10th February 2020

**Town & Country Planning Act 1990 (as amended)
Town & Country Planning (Development Management Procedure) (England) Order 2015
Application for Planning Permission for Works or Extension to a Dwelling**

Development Proposed front extension, fence and entrance gates

Location 23 Middleton Road Felpham

Proposed Porch, fence and gates Planning
Date January 2020
Scale 1:200 1:1250

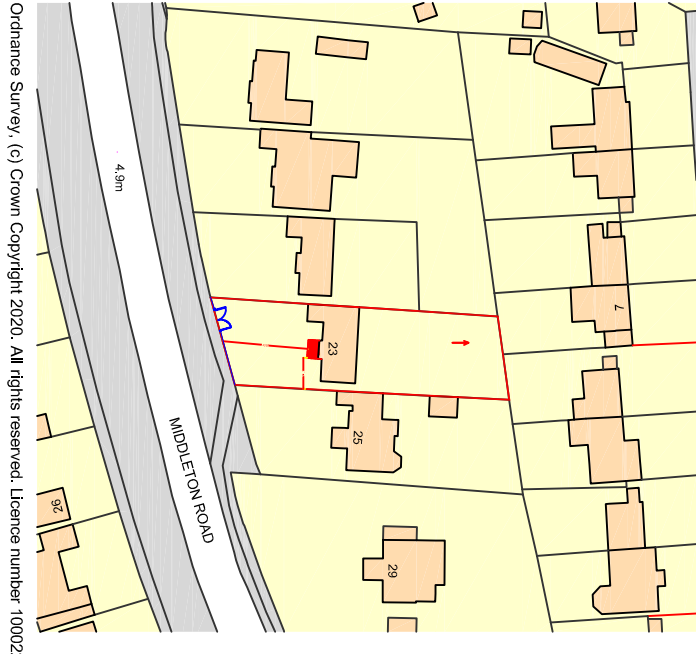
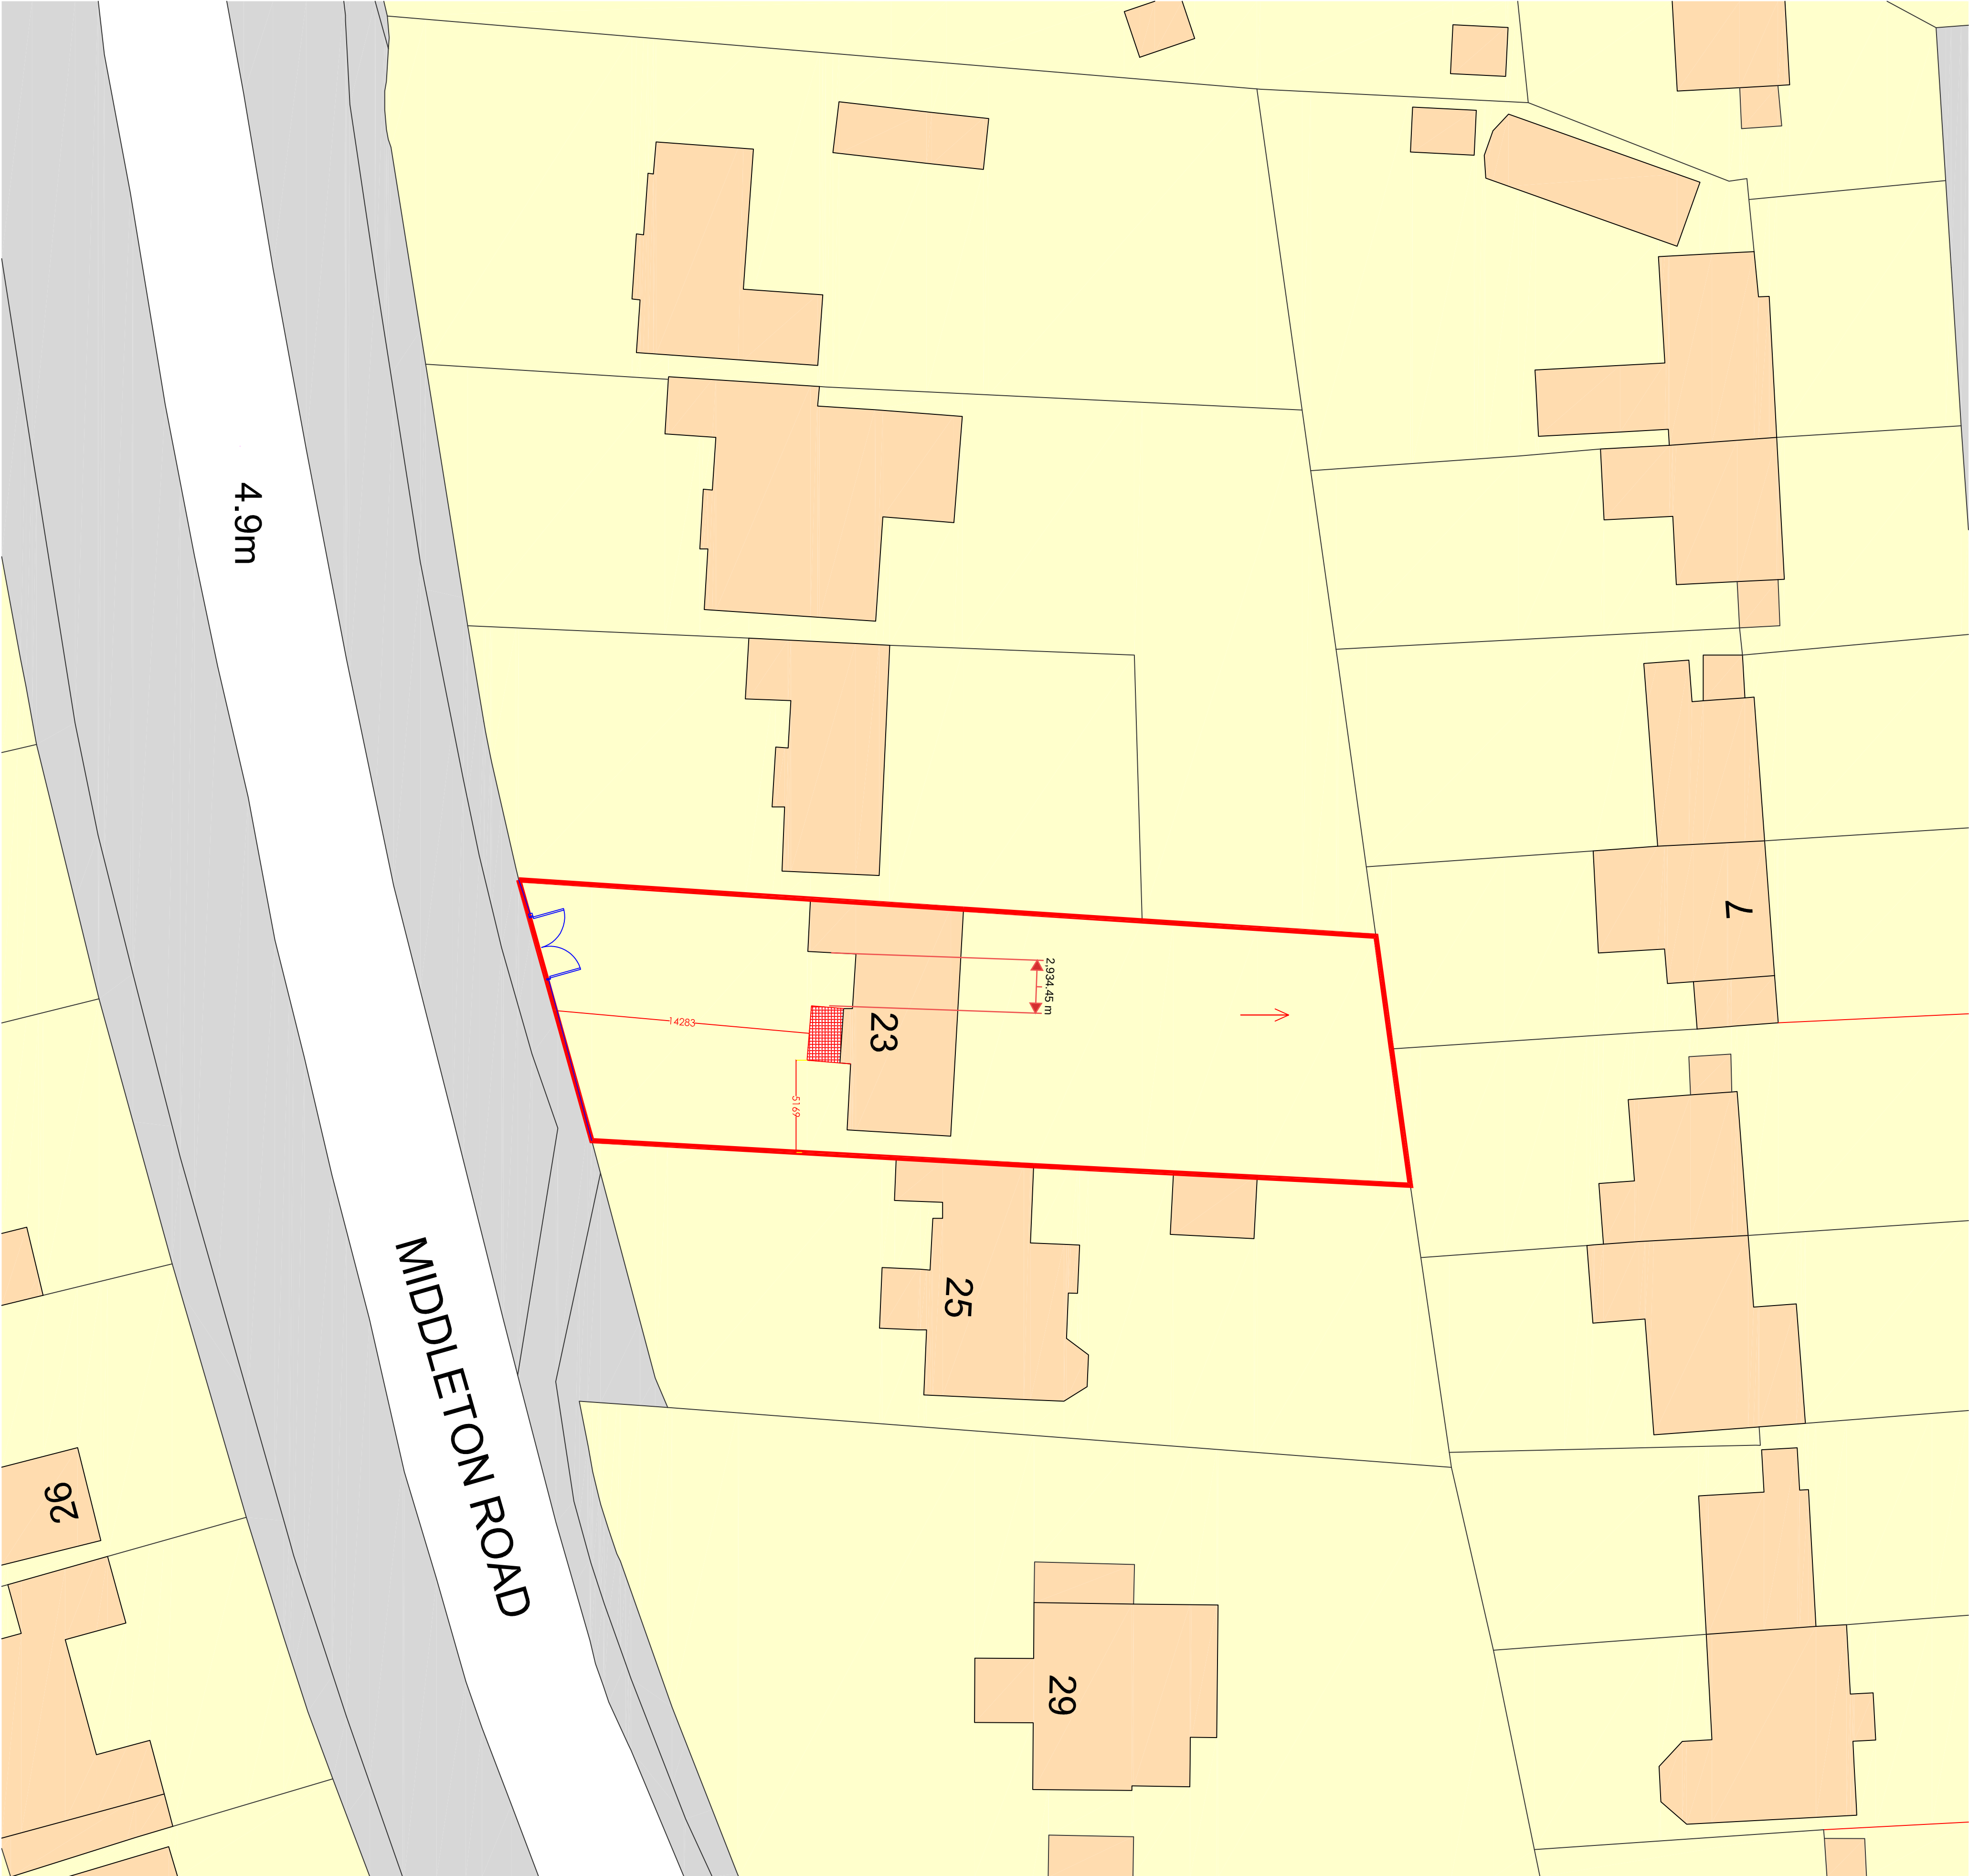
Block Plan: You are required to include dimensions on the block plan from the proposed extension to all site boundaries. Please amend.

Block Plan: You are required to show the fence and front extension on the block plan.
